Arun District Council
Arun Civic Centre
Maltravers Road
Littlehampton
West Sussex BN17 5LF
Planning & Building Control General Enquiries
Tel: (01903) 737756 Fax: (01903) 730442
Dx: 57406 Littlehampton
Minicom: 01903 732765
e-mail: planning@arun.gov.uk
website: www.arun.gov.uk/planning

Application No: EP/121/20/HH
Site Address: 49 Manor Road East Preston BN16 1QA
Description of works: First floor extension over existing garage

Thank you for your internet representation made on 27th November 2020 which has been recorded as an objection with the comments as follows:

DRG No 1132 - 3

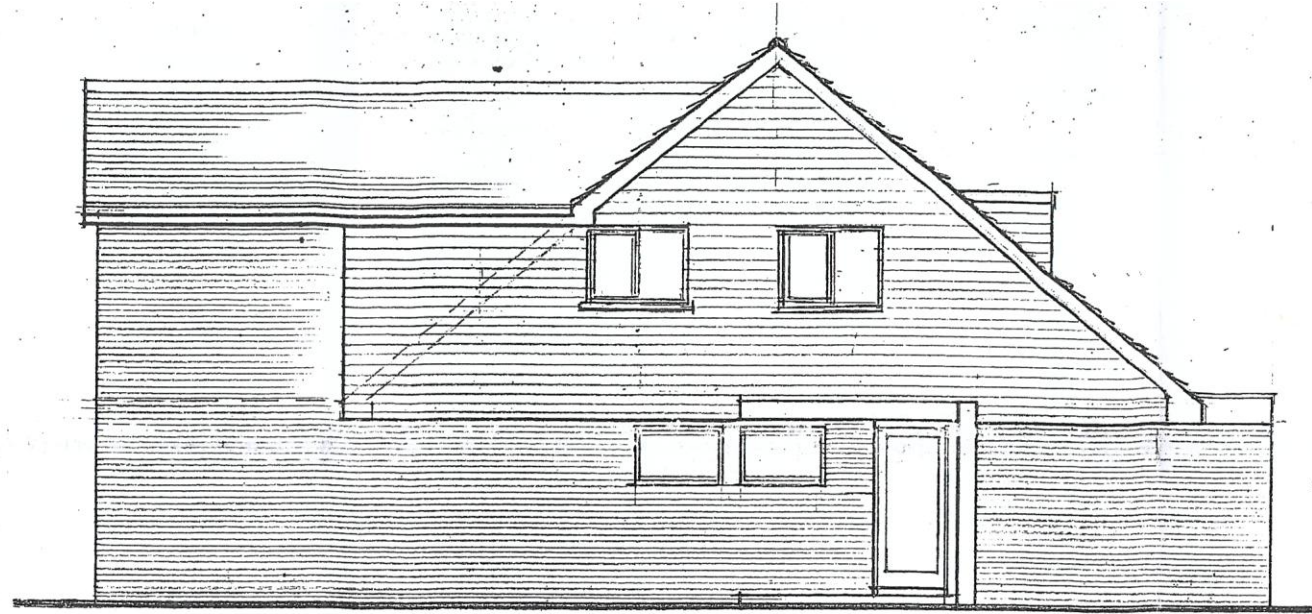
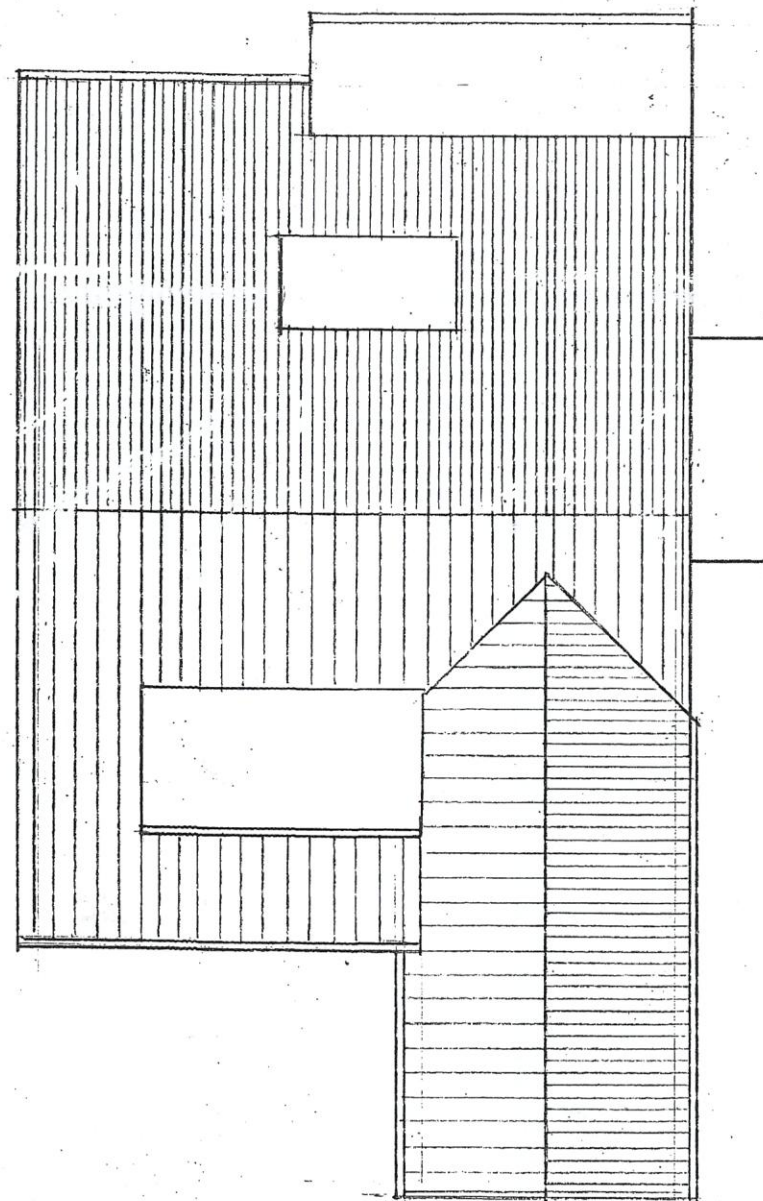
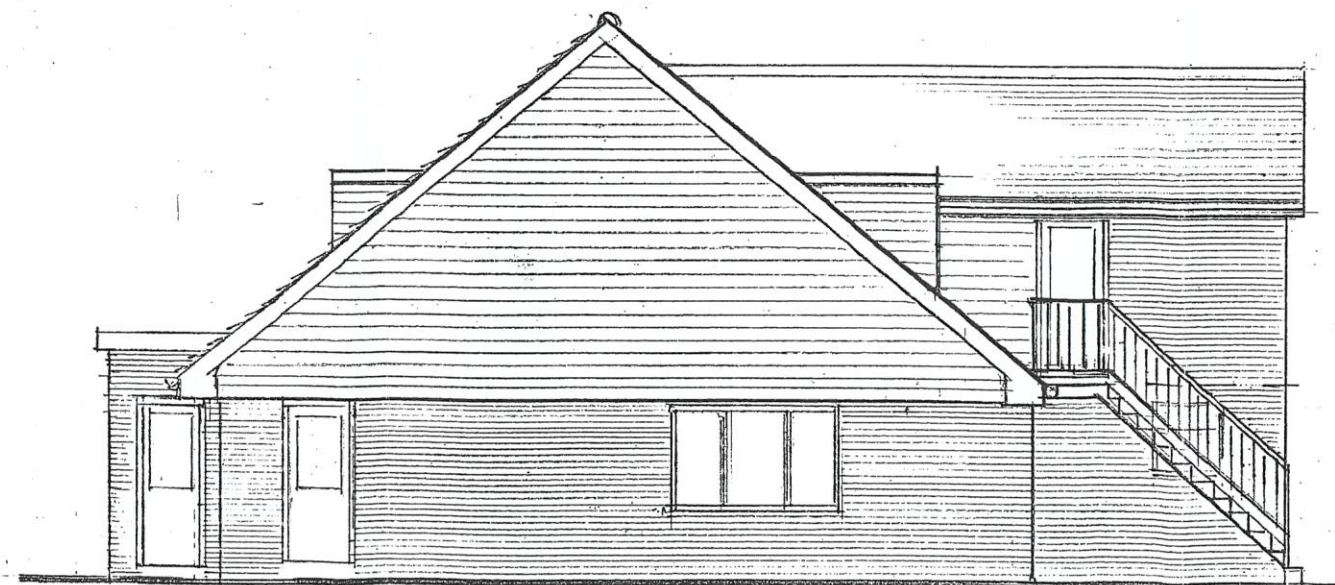
For information the east and west elevations on drawing 1132-3 are the wrong way round.

DRG No 1132-4 D

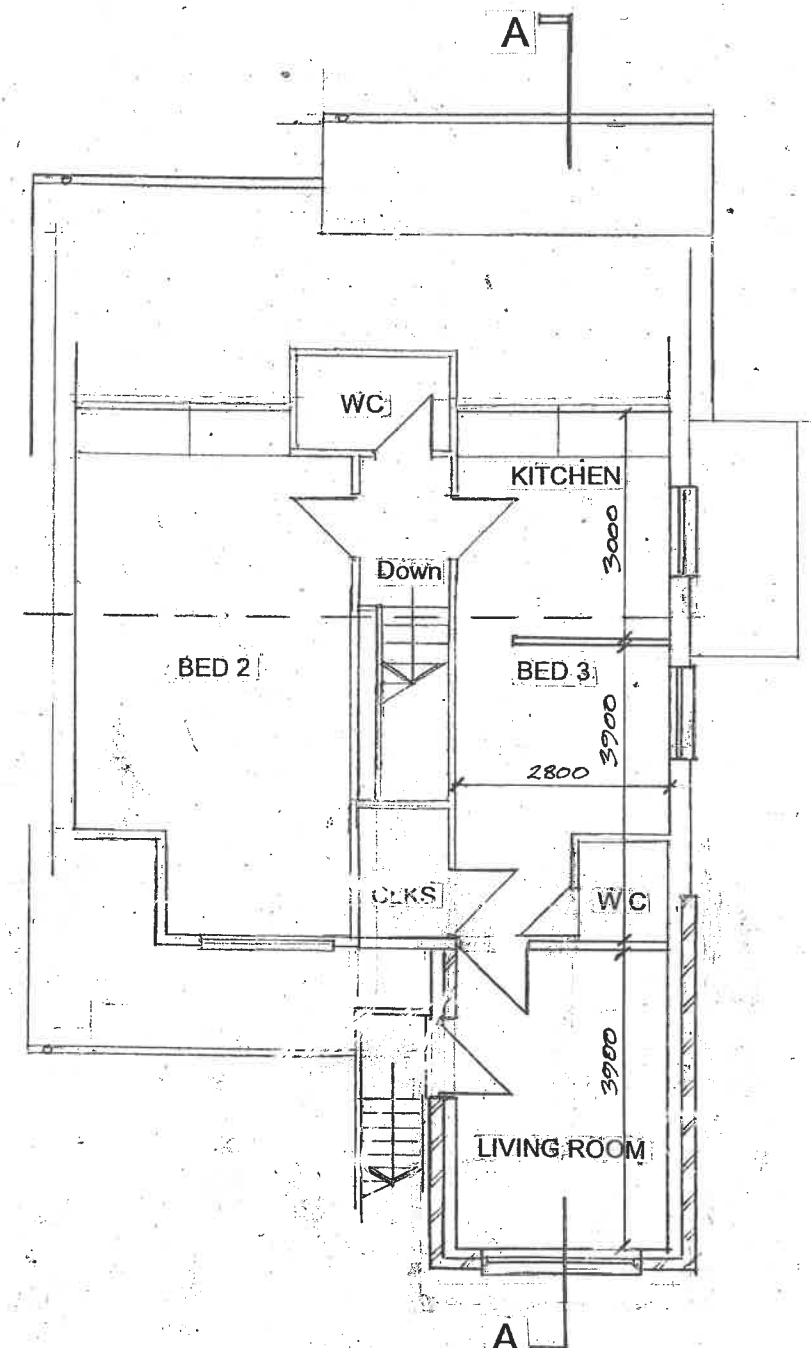
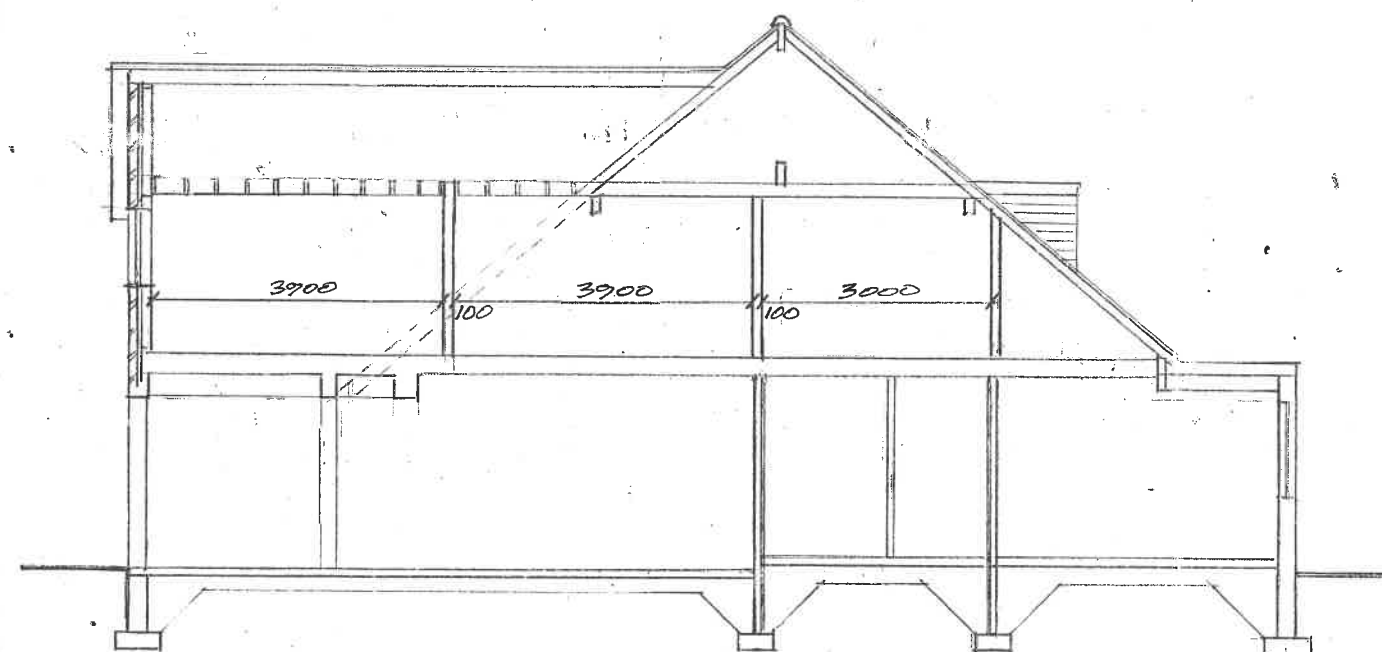
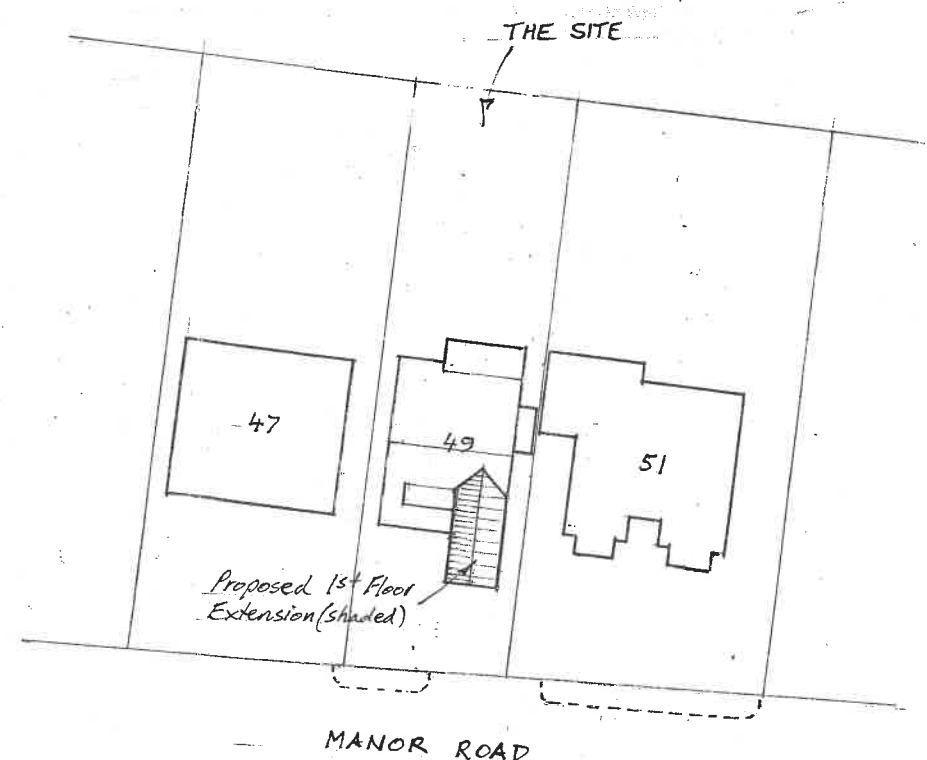
The proposal also conflicts with Policy D DM4 as it does not sympathetically relate to nor is it visually integrated with the existing building in massing, design, form scale and materials. The proposed extension brings the property well forward of the established building line and is therefore a negative impact upon the spatial character of the area.

Paragraph 4.16 of the East Preston Neighbourhood Plan states, Extensions should be designed to look as if they were part of the original design of the house. The proposed redevelopment of this property may not look part of the original design of the house, especially with an external staircase to the front of the property.
